## **DEPARTMENT OF PUBLIC WORKS**

### **MEMORANDUM**

**TO:** All Staff  
**FROM:** Public Works Plan Review Team  
**DATE:** March 16, 2026  
**SUBJECT:** SX-26-00005 Wadkins - Updated

JACK WADKINS
YAKIMA RIVER DRIVE
TAX PARCEL NO. 016333

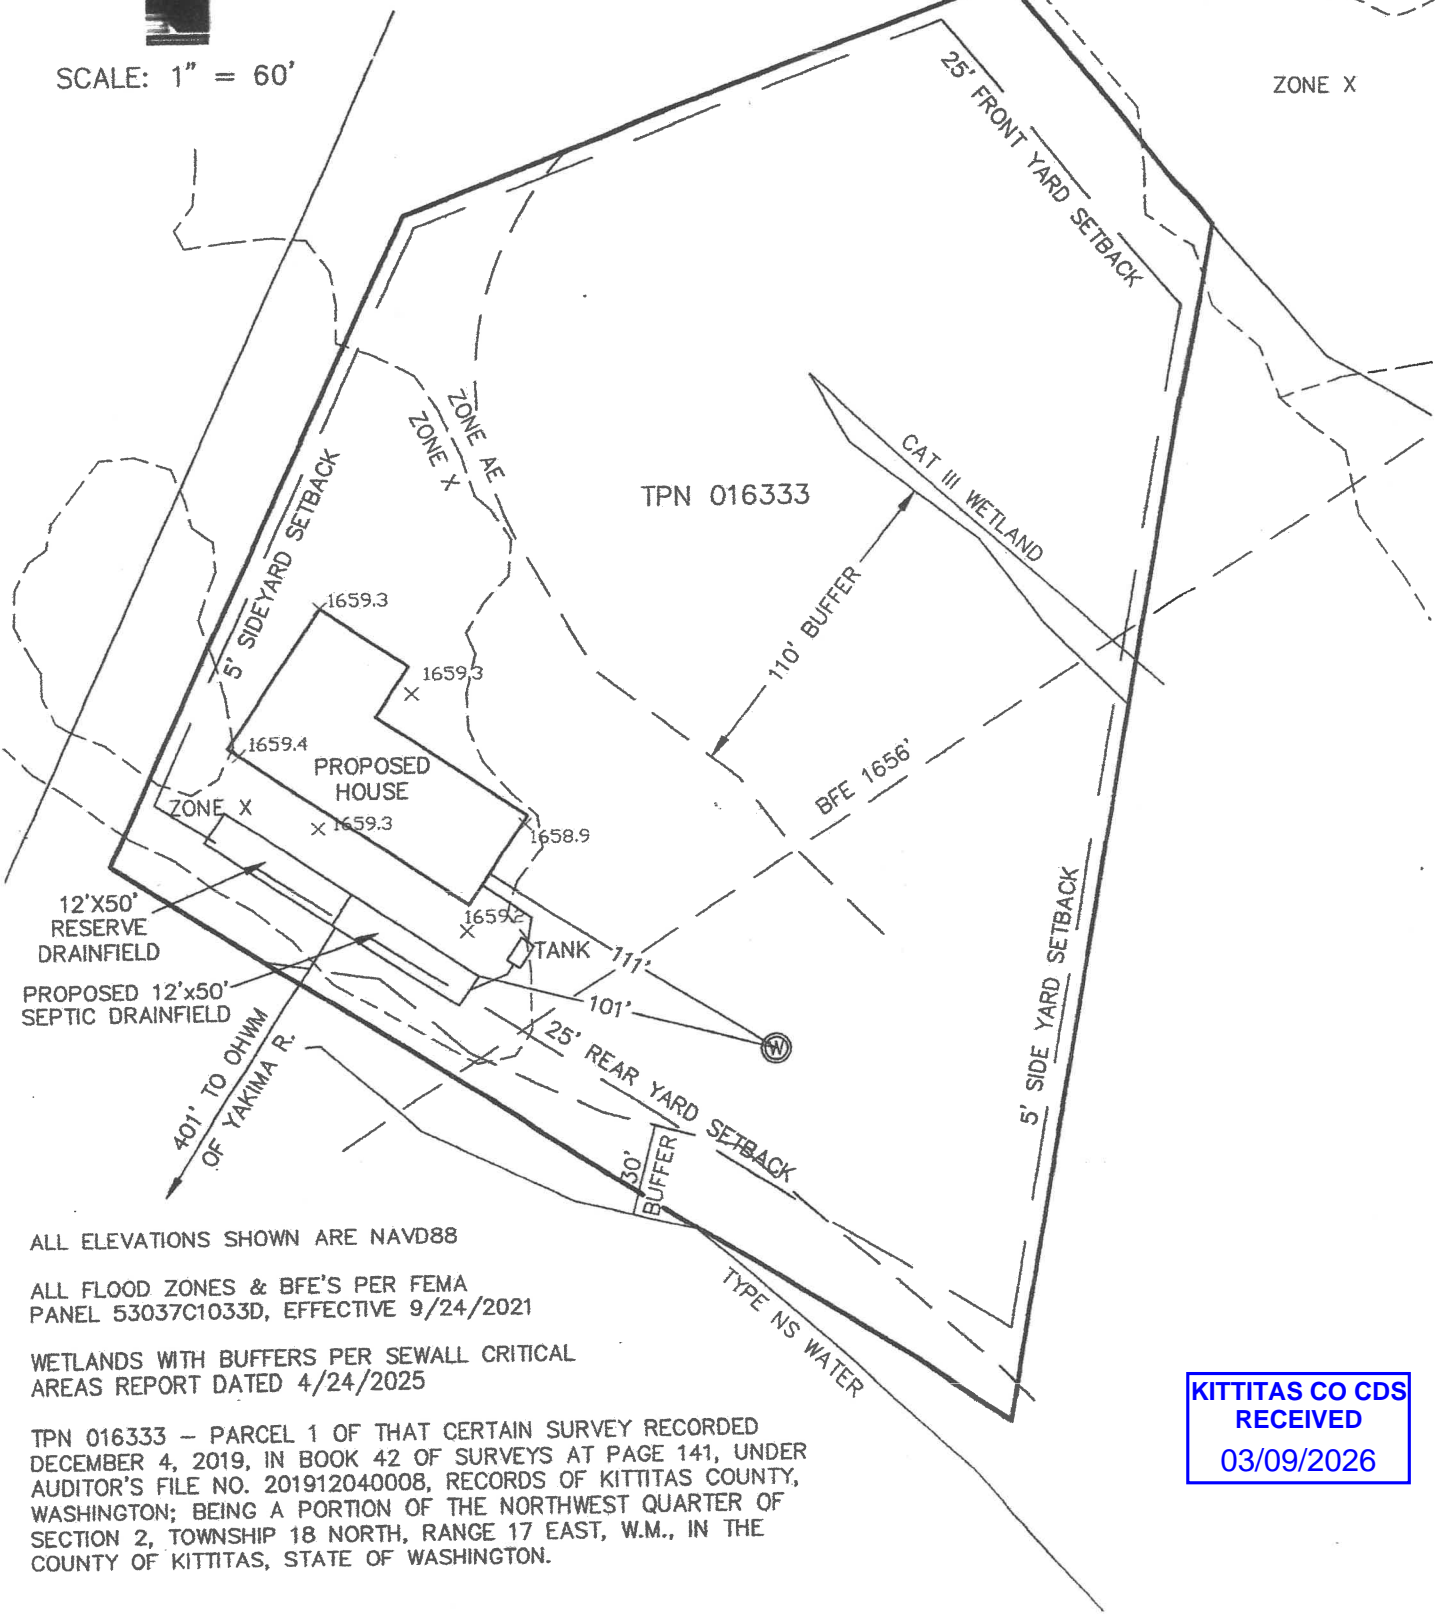
<b>ENGINEERING</b>	Except as exempted in KCC 14.05.060, no grading or filling upon a site involving more than one hundred (100) cubic yards shall be performed without a grading permit from the County Engineer or Public Works designee (KCC 14.05.050). An application for grading in excess of five hundred (500) cubic yards shall be accompanied by an engineered grading plan (KCC 14.05.080). (CBP)
<b>FLOOD</b>	A majority of parcel #016333 is mapped within the FEMA identified special flood hazard area (1% annual chance flood zone). A floodplain development permit is required for the propane tank and solar panels that will be installed within the special flood hazard area. (SC)
<b>WATER MITIGATION/ METERING</b>	No comments. (SC)
<b>AIRPORT</b>	No Comments. (RC)
